**From:** [REDACTED]@rwe.com  
**Sent:** 20 June 2024 10:32  
**To:** Byers Gill Solar  
**Cc:** [REDACTED]@arup.com; [REDACTED]@arup.com; [REDACTED]@arup.com; [REDACTED]@arup.com; [REDACTED]@burgess-salmon.com; [REDACTED]@burgess-salmon.com  
**Subject:** RE: Byers Gill Solar - new or revised information  
**Categories:** With ExA

As discussed, we are pleased to update the Examining Authority (“**ExA**”) that on 28 February 2024 the Applicant and a landowner completed an option agreement for a cable easement over land within the Order limits comprising a section of the off-road cable route option to the south of Bishopton (the “**Easement Option**”).

Sheet 9 of 13

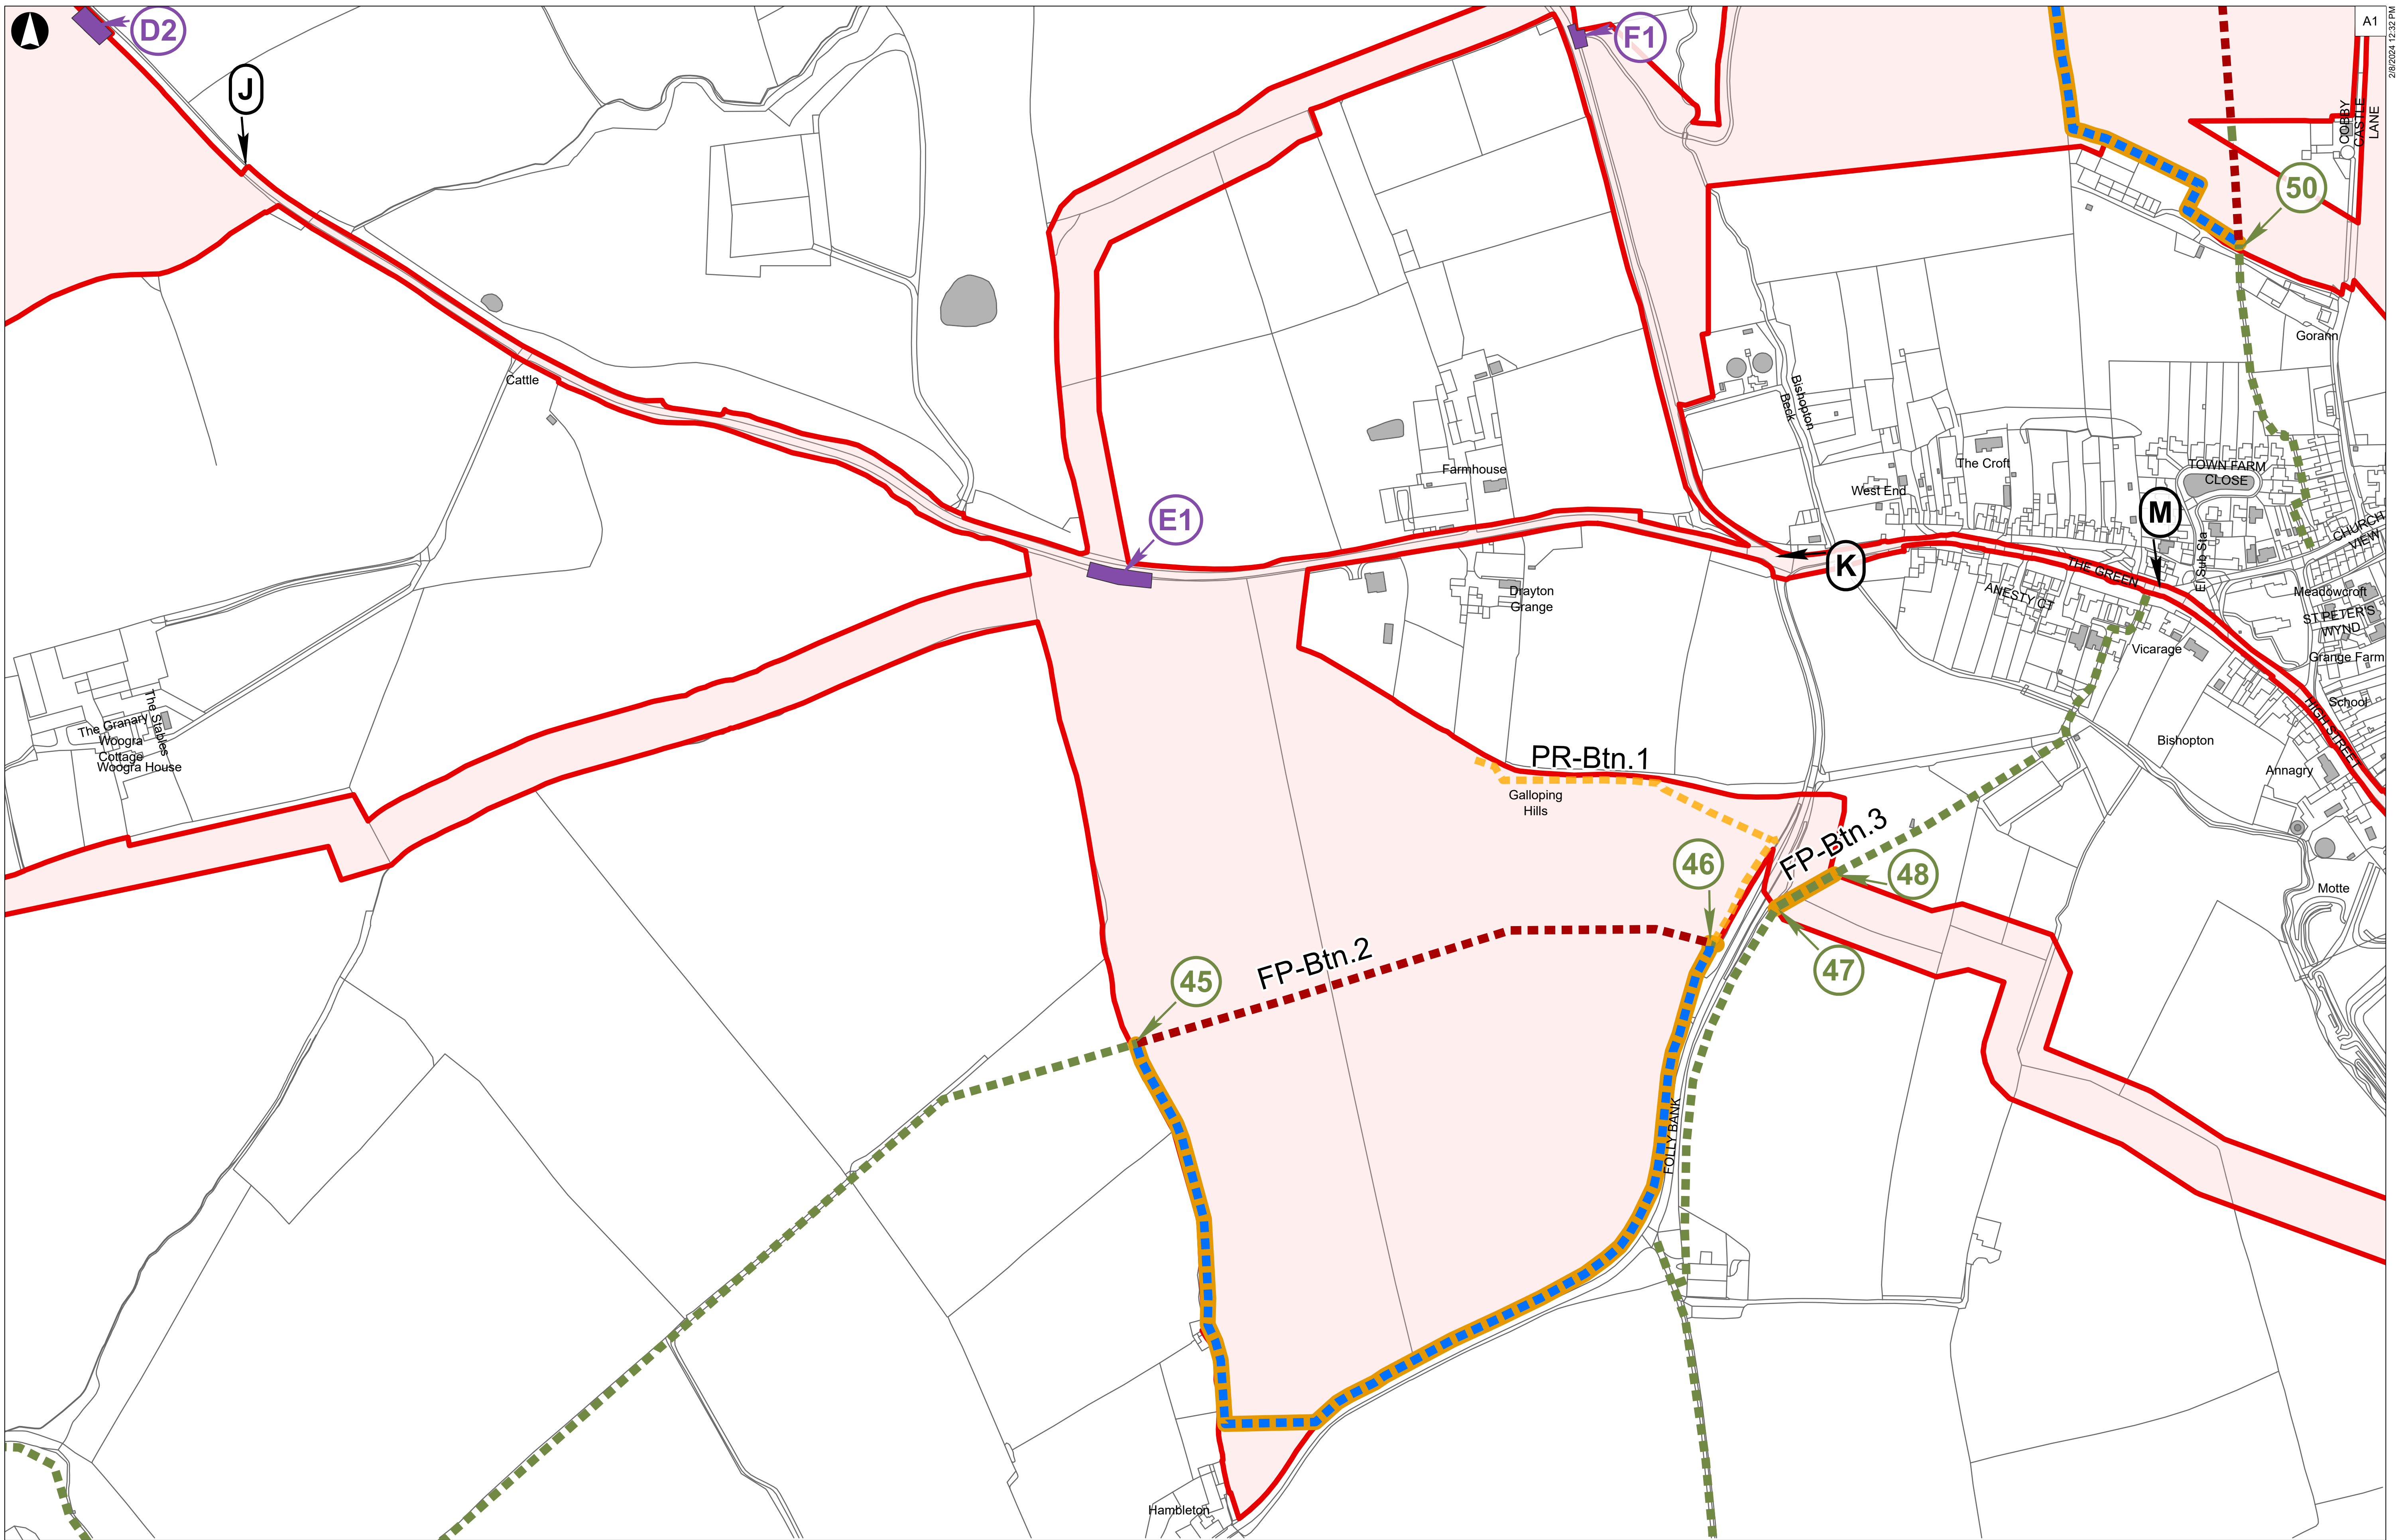
The update to the application would involve removing the on-road option for 132kV cabling which currently follows the section of adopted highway through Bishopton known as The Green and High Street. The proposed removal is shown on an indicative Red Line Boundary overview plan extract below. This land comprises part of plots 9/6 and 11/11 and the whole of plot 11/8 and is no longer necessary to guarantee delivery of the Proposed Development now that the Easement Option is secured.

- Location Plan **[Document Reference: APP-007]**
- Works Plans - sheets 9 and 11 **[Document Reference: APP-008]**
- Street Works, Rights of Way and Access Plans - sheets 9 and 11 **[Document Reference: APP-009]**
- Land Plans – sheets 9 and 11 **[Document Reference: APP-010]**
- Environmental Masterplans - sheets 9 and 11 **[Document Reference: APP-011]**
- Book of Reference (further to the updates made at submission of the Section 59 Certificate) **[Document Reference: APP-015]**
- Statement of Reasons, Appendix A **[Document Reference: APP-014]**
- Draft DCO **[Document Reference: APP-012]**, namely:
  - Schedule 3 (Streets Subject to Street Works),
  - Schedule 8 (Land In Which only New Rights Etc. May Be Acquired)
- ES Figure 2.13 Underground Cable Routes
